Phone: (01772) 530695  
Fax:  
Email: [niamh.osullivan@lancashire.gov.uk](mailto:niamh.osullivan@lancashire.gov.uk)  
Your ref:  
Our ref: NO/NH  
Date: 6 August 2014

**PLANNING APPLICATION 3/014/0618 FULL PLANNING APPLICATION FOR RESIDENTIAL DEVELOPMENT (10 DWELLINGS) AT LAND OFF CHATBURN OLD ROAD, CHATBURN**

Title: Planning Drawings - Proposed Location Plan

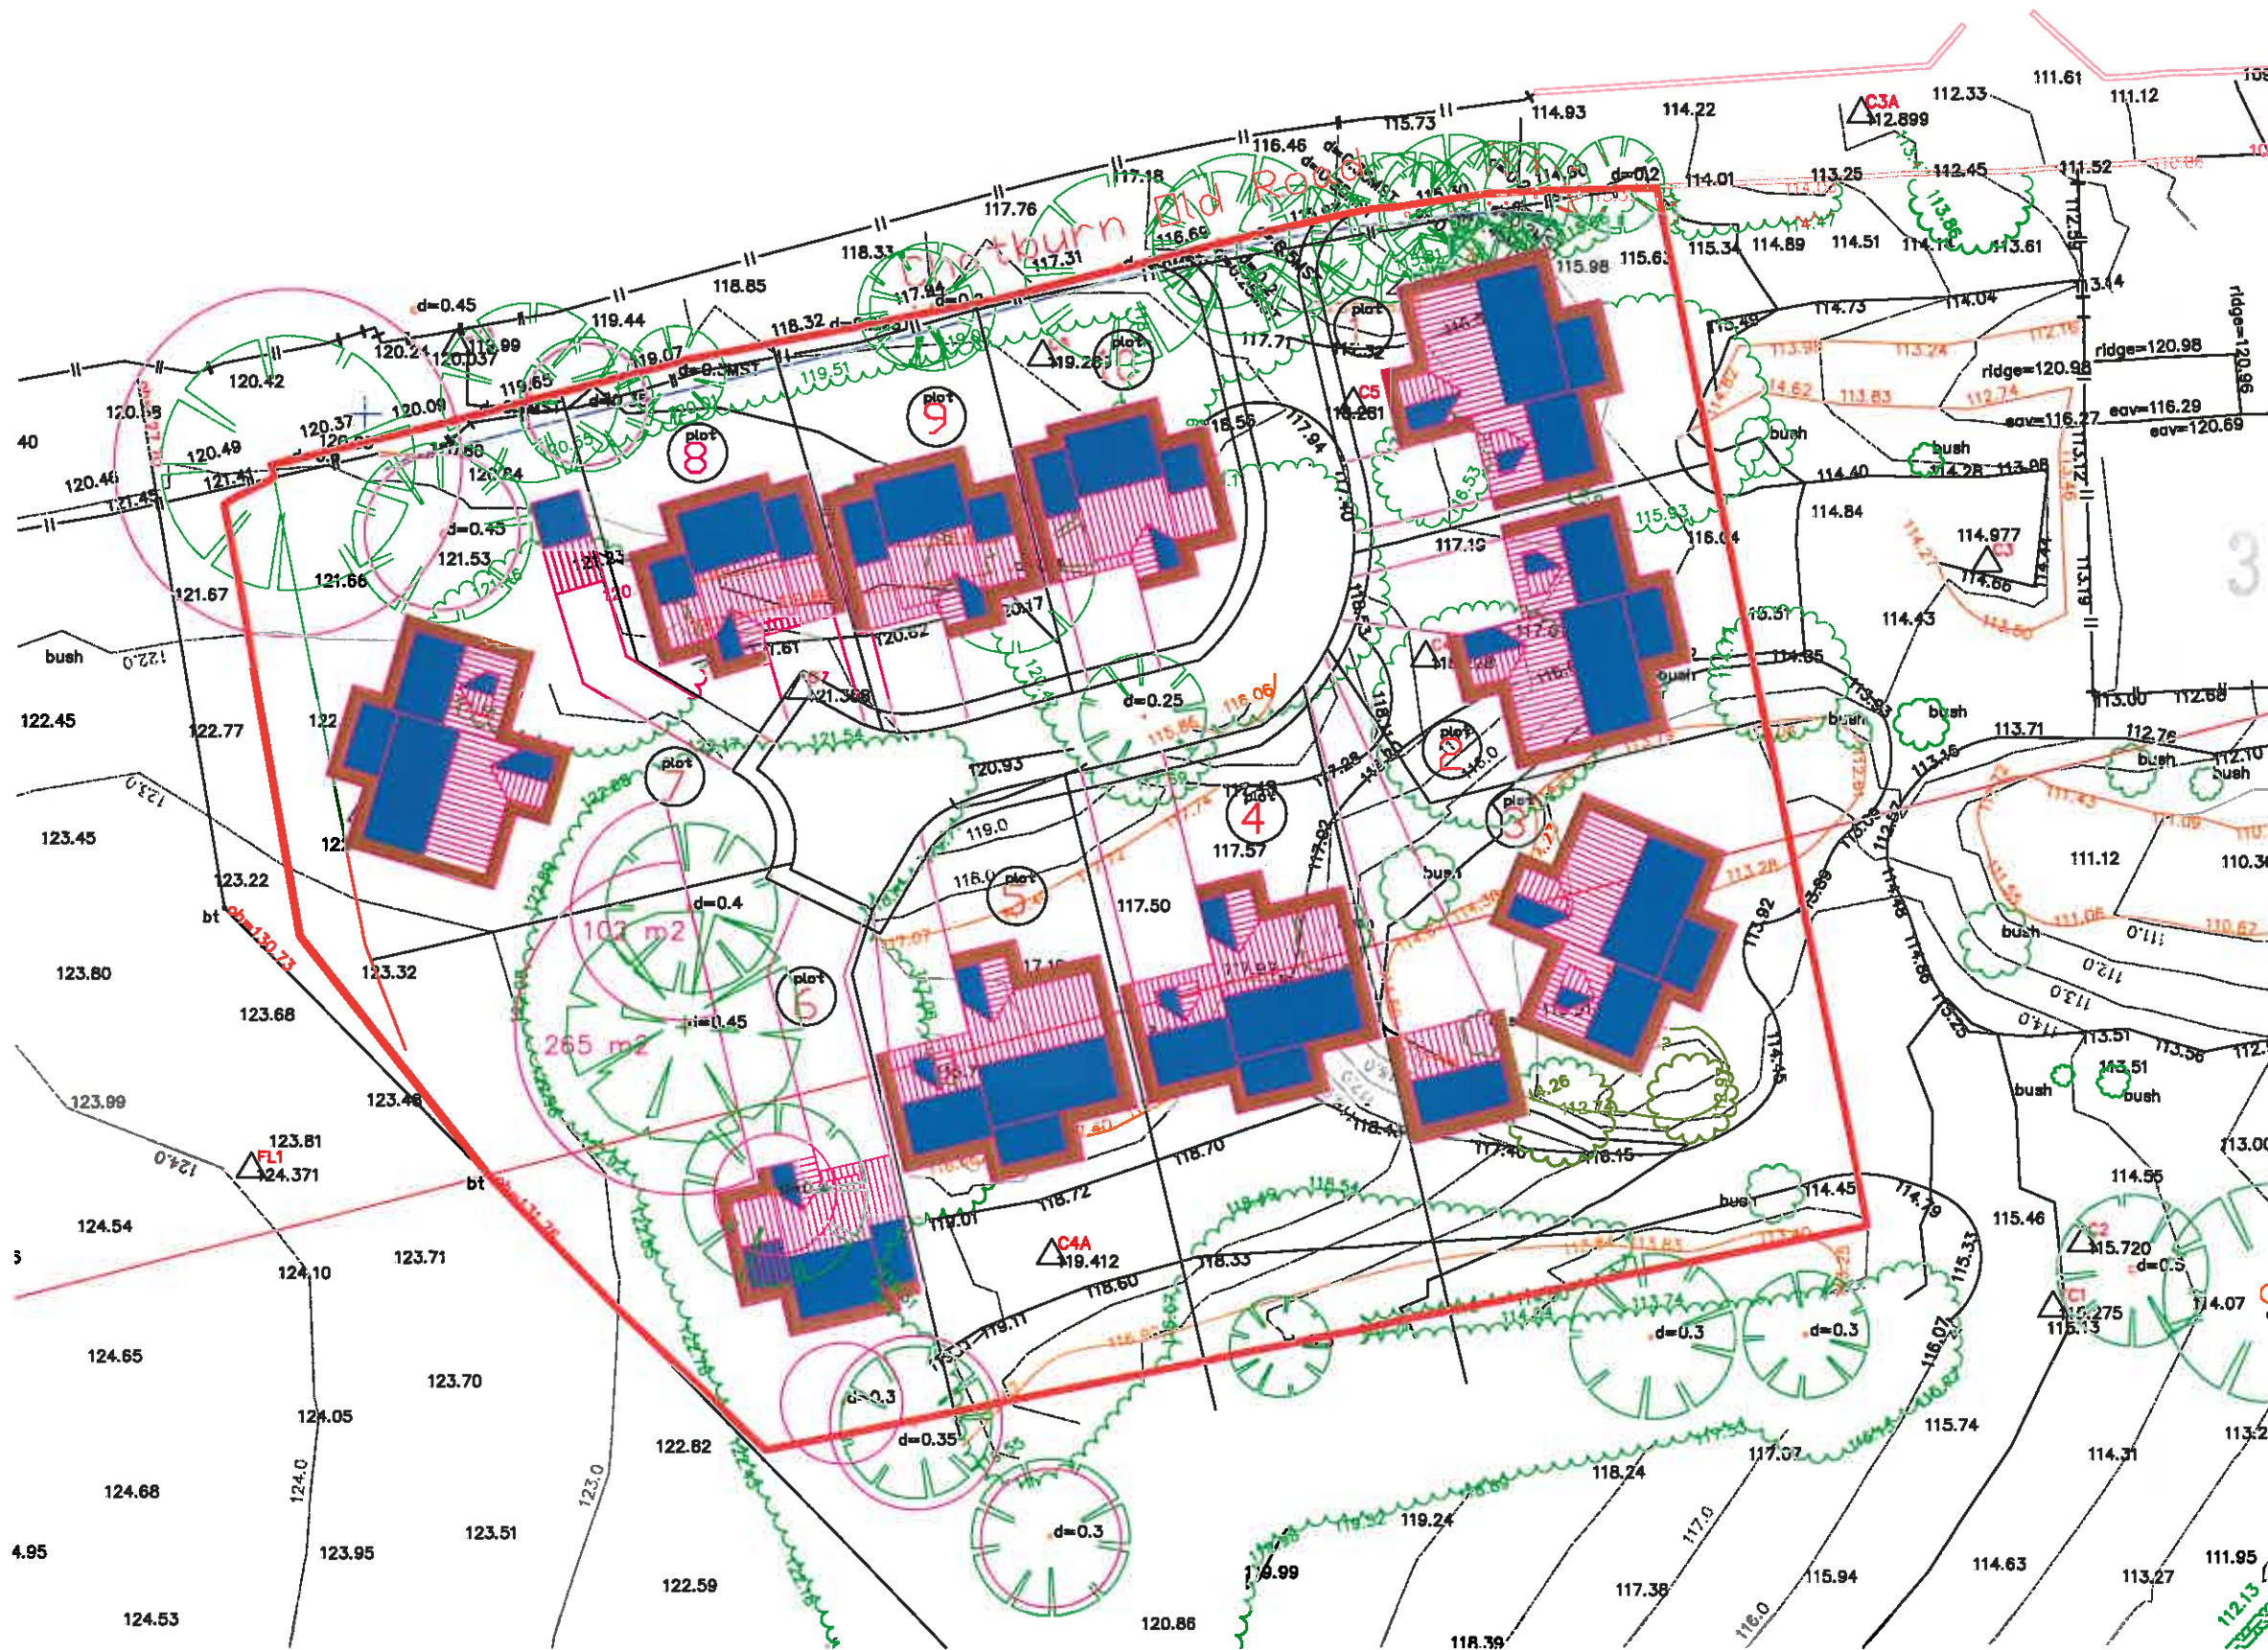
This application is a change to position of some properties moving them closer to Lanehead Quarry. We have commented on the previous application and we provide our comments below on this new application.

However, this application moves some properties nearer to the quarry than the previous application which may result in a greater number of complaints or objections to any future development at the site.
